Re: Permit # SHL18-017
Project Name Fallquist Community Dock
Project Address 5067 84th Ave SE (parcel # 407600-0800)
Reviewer Nicole Guadette, Senior Planner
Department Planning & Development

Below are our responses to the corrections in your letter dated June 4, 2019. Your original comments are in ***bold italics*** followed by our response in plain text.

Sheet 2 of 6 **Date:** 4/9/2020

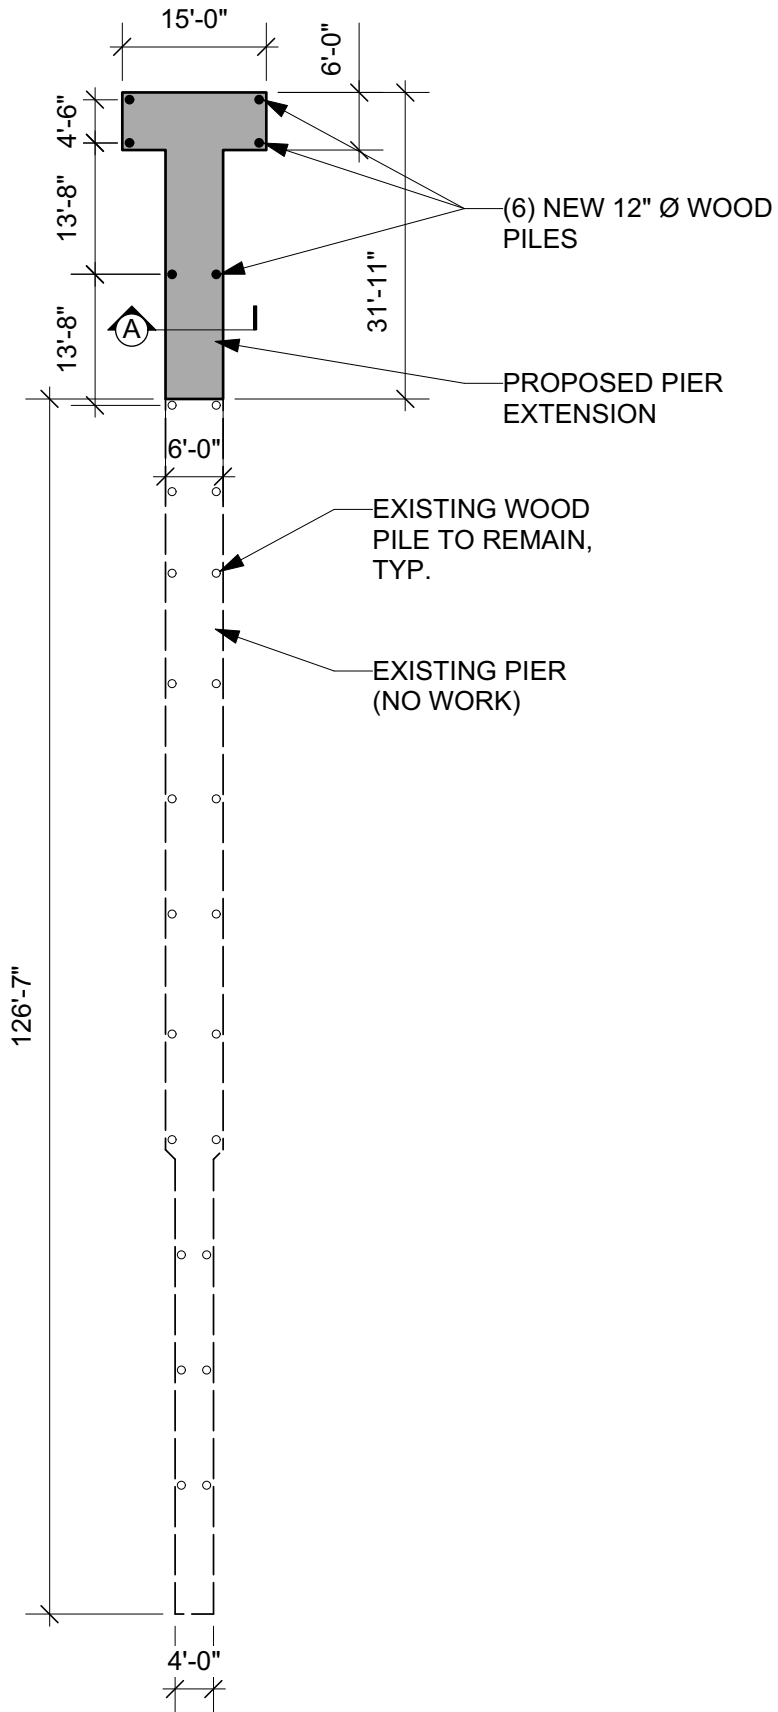
4. Please update the project plans to show the work requested by this permit (the extension of the dock). The plans will need to indicate that repair work (narrowing of the first 30-feet of dock, replacement of decking, and repair of pilings) is being addressed by a separate permit application, SHL19-005.

A note has been added to sheet 2 stating that the existing pier will be repaired under SHL19-005.
